CITY OF ALBUQUERQUE

Re: Broadstone Santa Monica, Buildings 26 & 27
Request for Permanent C.O. – Not Accepted
Engineer's Stamp dated: 04-10-12, (D18/D054)
Certification dated: 05-15-13

Based upon the information provided in the Certification received 05-15-13, the above referenced Certification is not acceptable for release of a Permanent Certificate of Occupancy by Hydrology. The following comments need to be addressed before a CO is given for phase 3.

FILE:M:\CADD FILES\1900-1999\1900\CG-201.dwg DATE:Apr. 10 2012 TIME: 10:57 am USER:Bryan CG-201.dwg

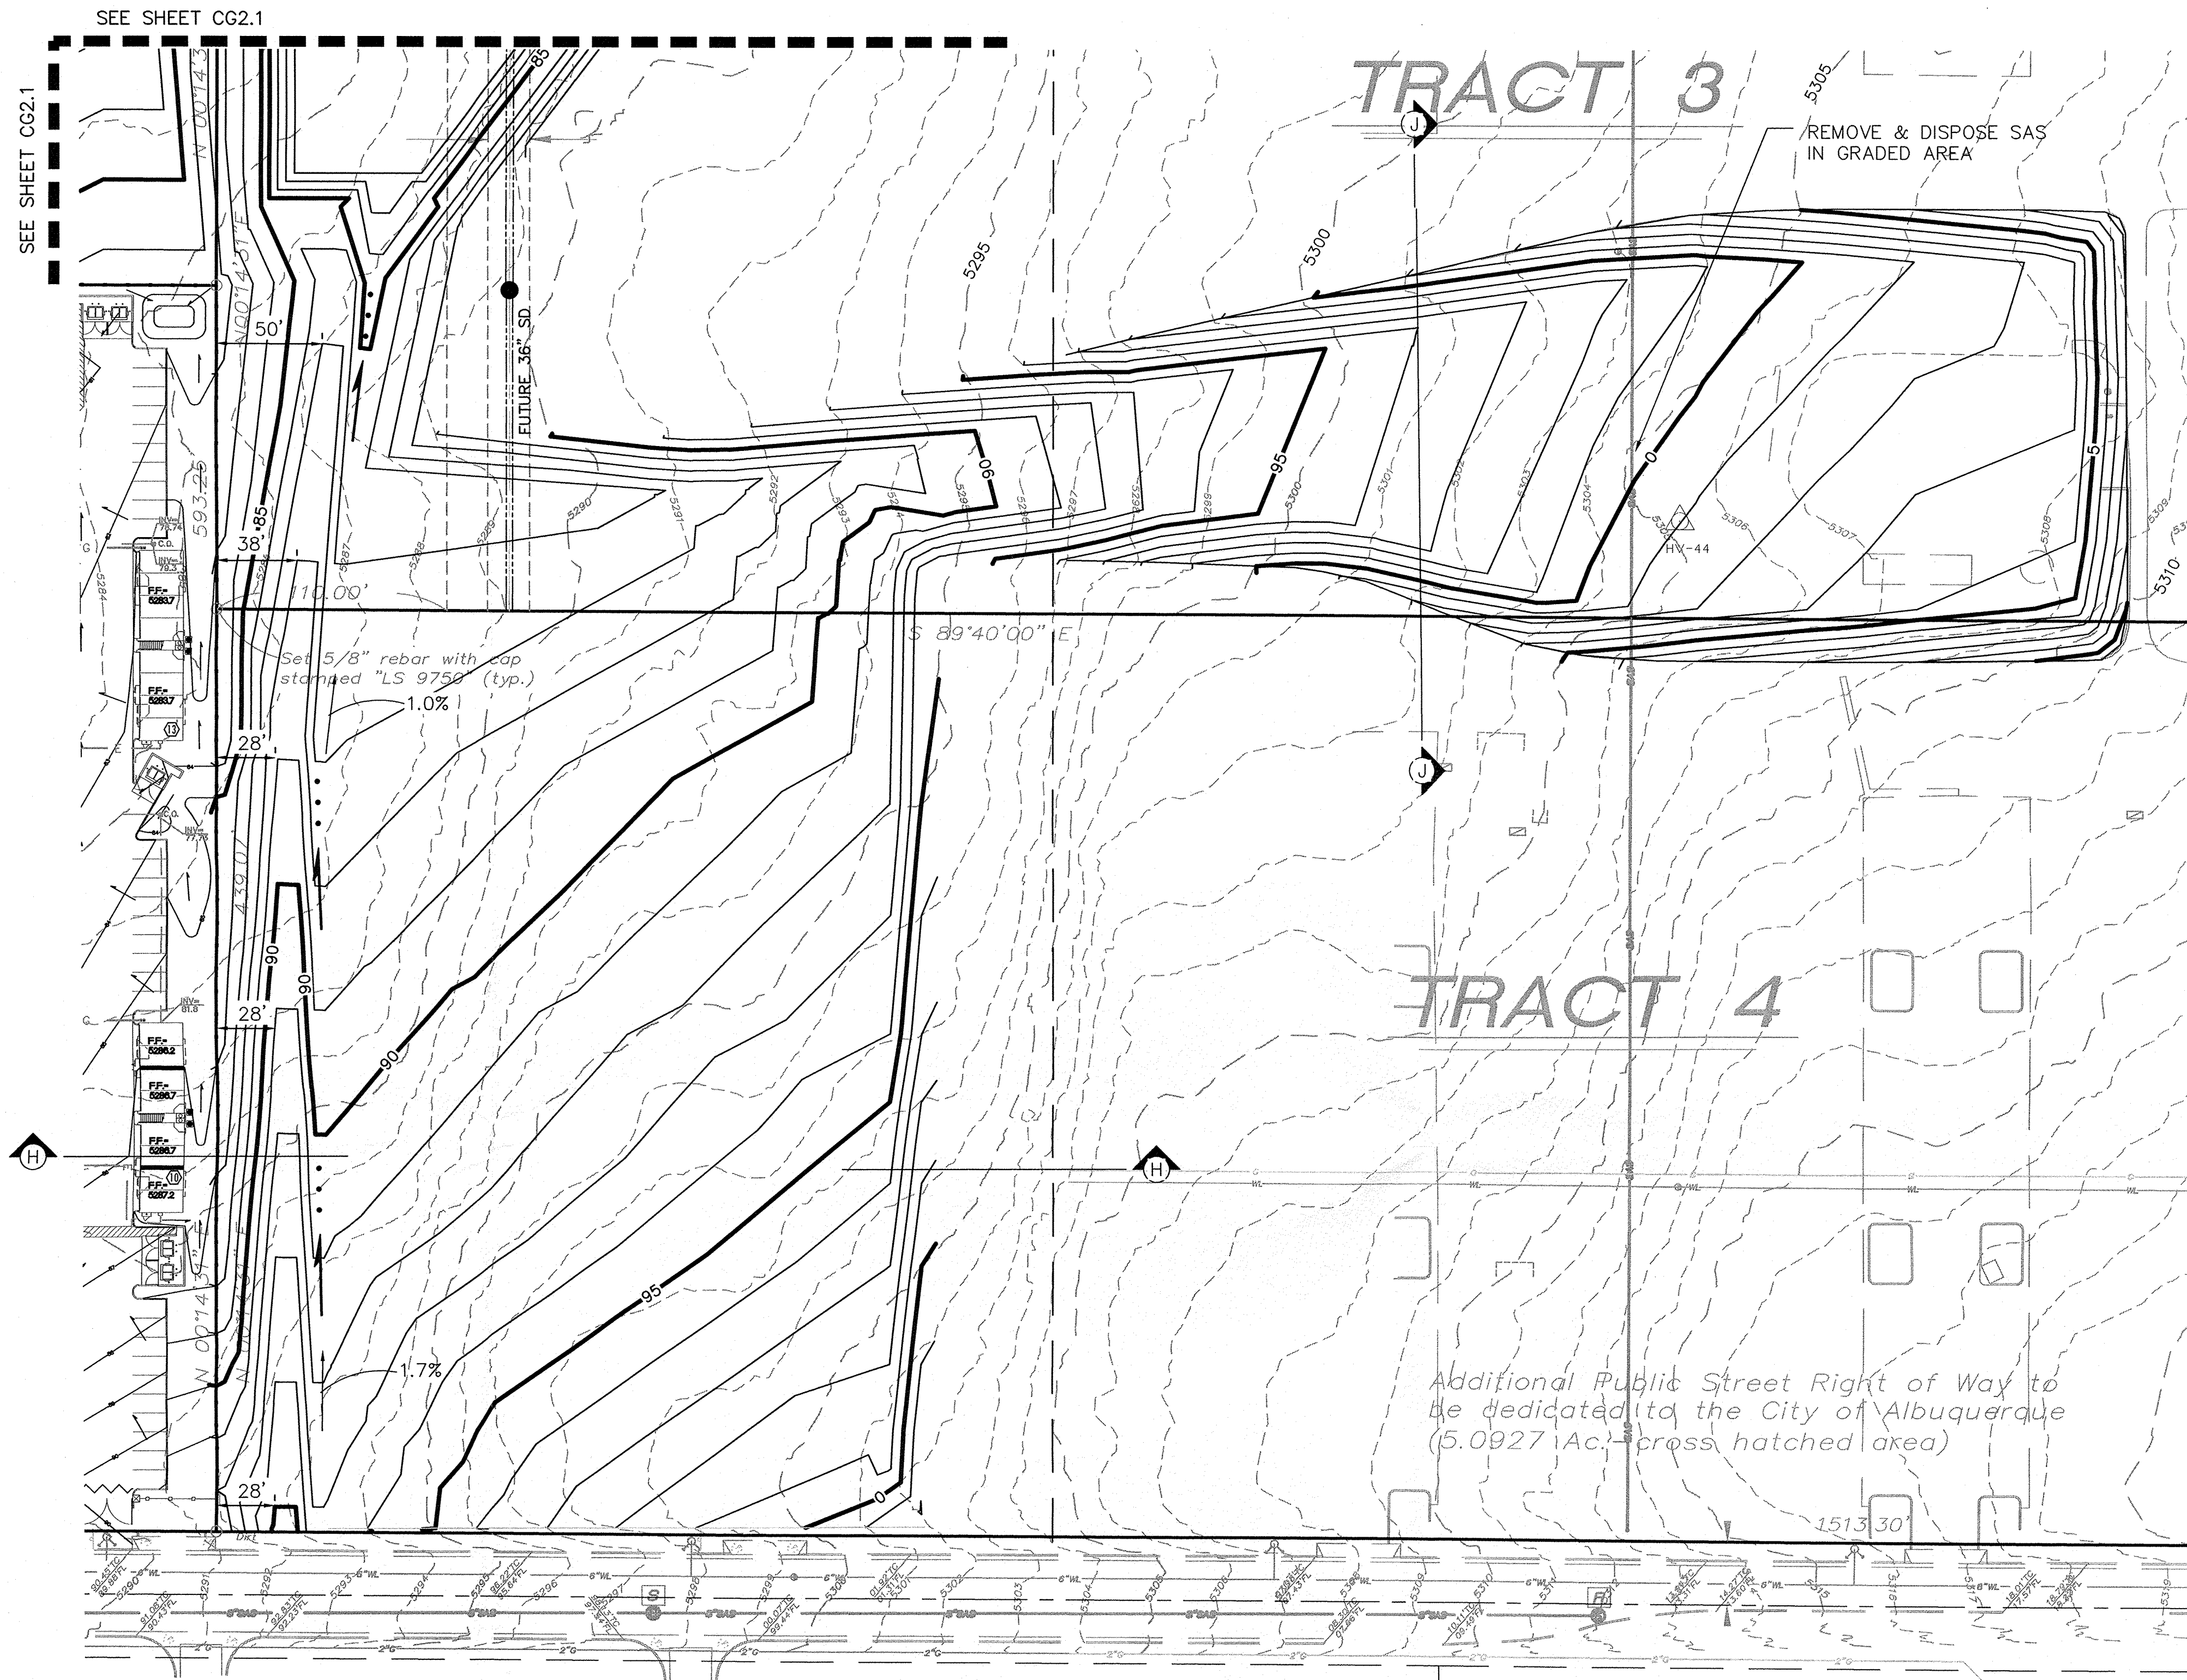
1. Include certification language and seal on sheets CG.1 and CG.2
2. The berm along Derickson Ave does not appear to be compacted to the specified 90% compaction.
3. There is a low spot at the construction entrance allowing flows to enter Derickson Ave. instead of flowing to the inlet at the NW pond. There is also a high spot just to the west of the entrance.
